Prior Notification for Permitted Development

Schedule 2 Part 3 Class MA

Development: Prior approval under Schedule 2, Part 3, Class MA for the change of use from a business (Class E) to 1 No flats (C3).
Location: 78 A High Street Littlehampton BN17 5DX

DRAWN BY W.A	CHECKED BY	DATE 03-12-2025
SCALE 1 : 100	DRAWING No 112504-01

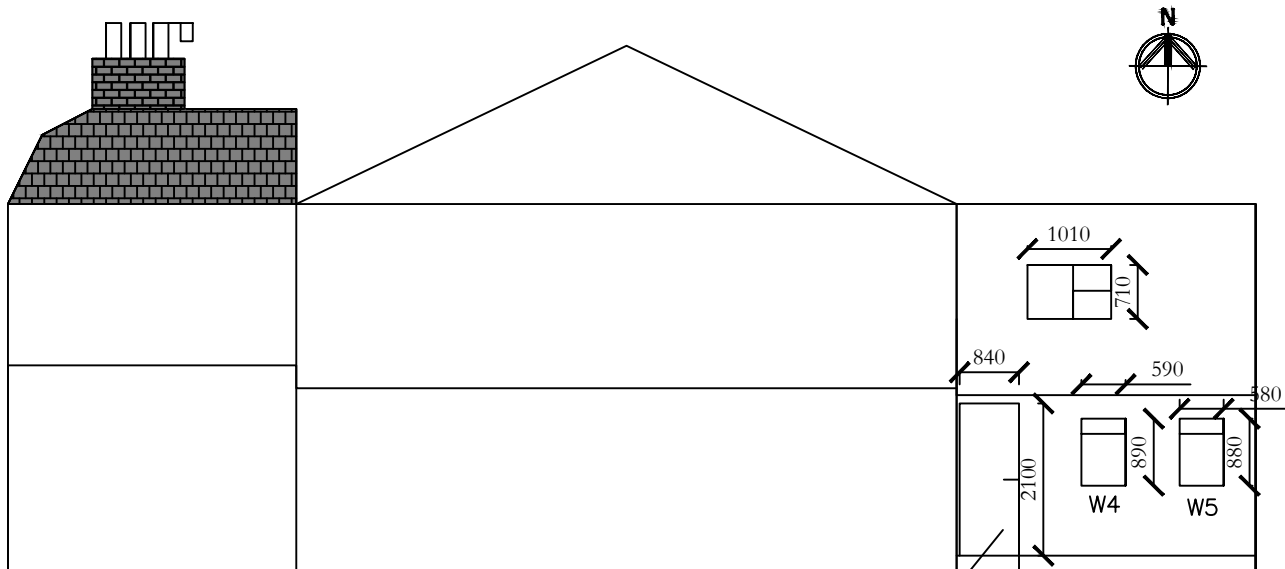
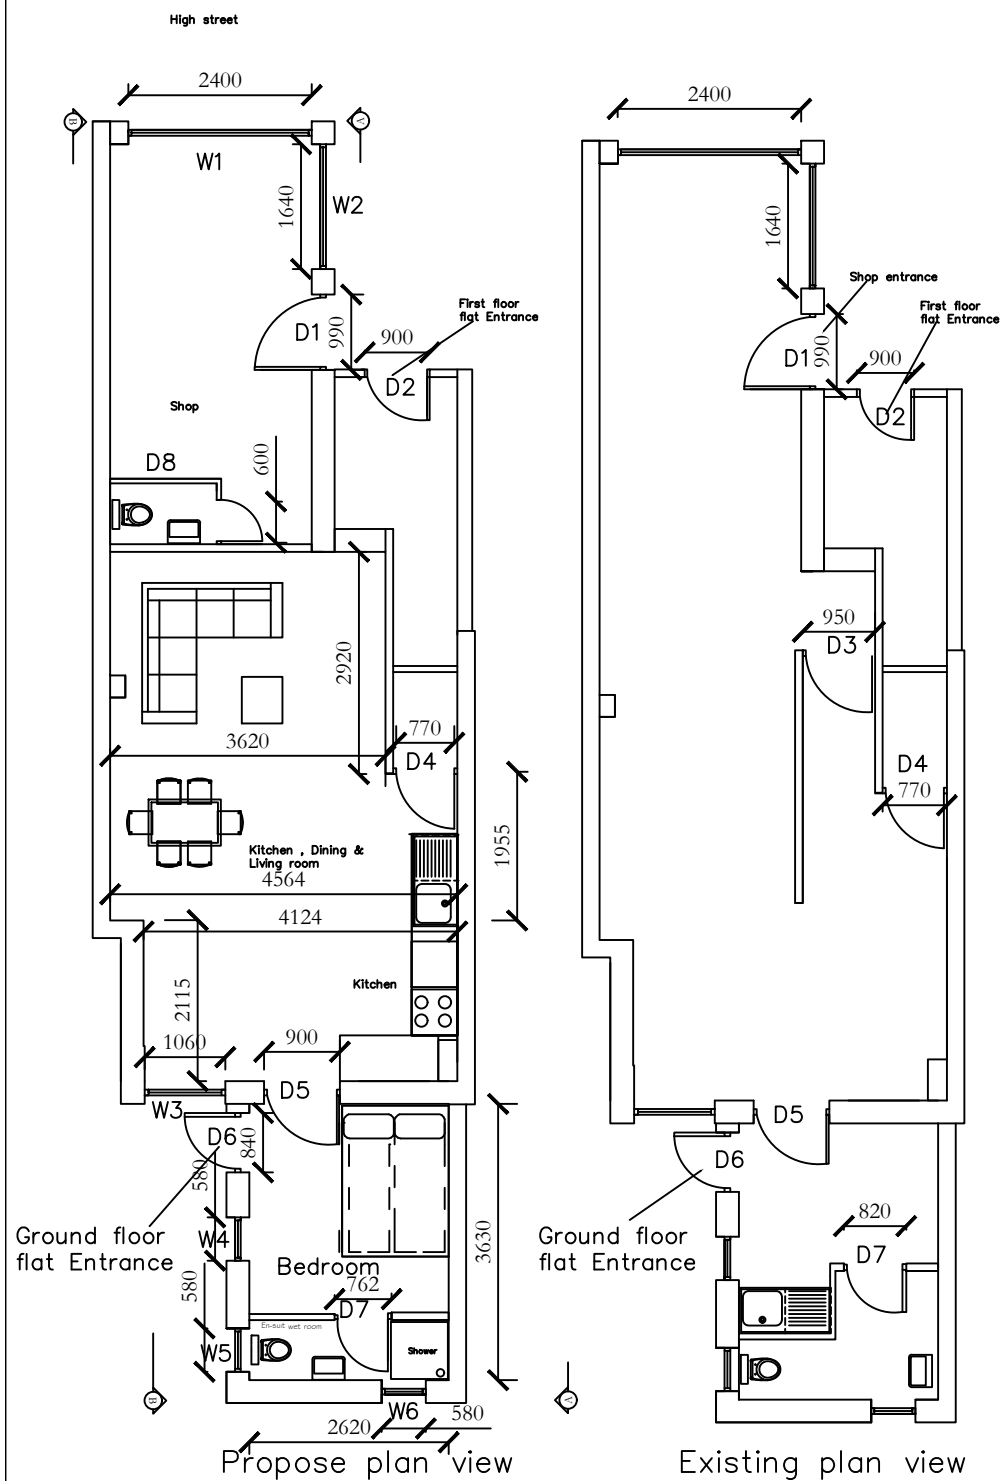
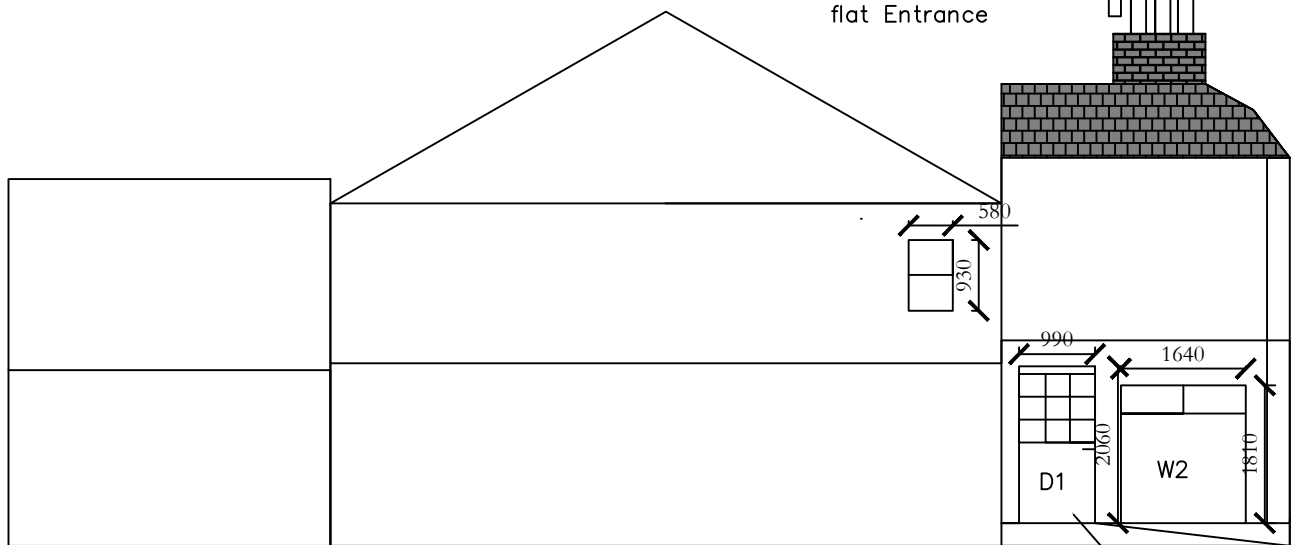
Please provide the dimensions of the windows and doors and the proposed use of each room on the proposed floor plan.
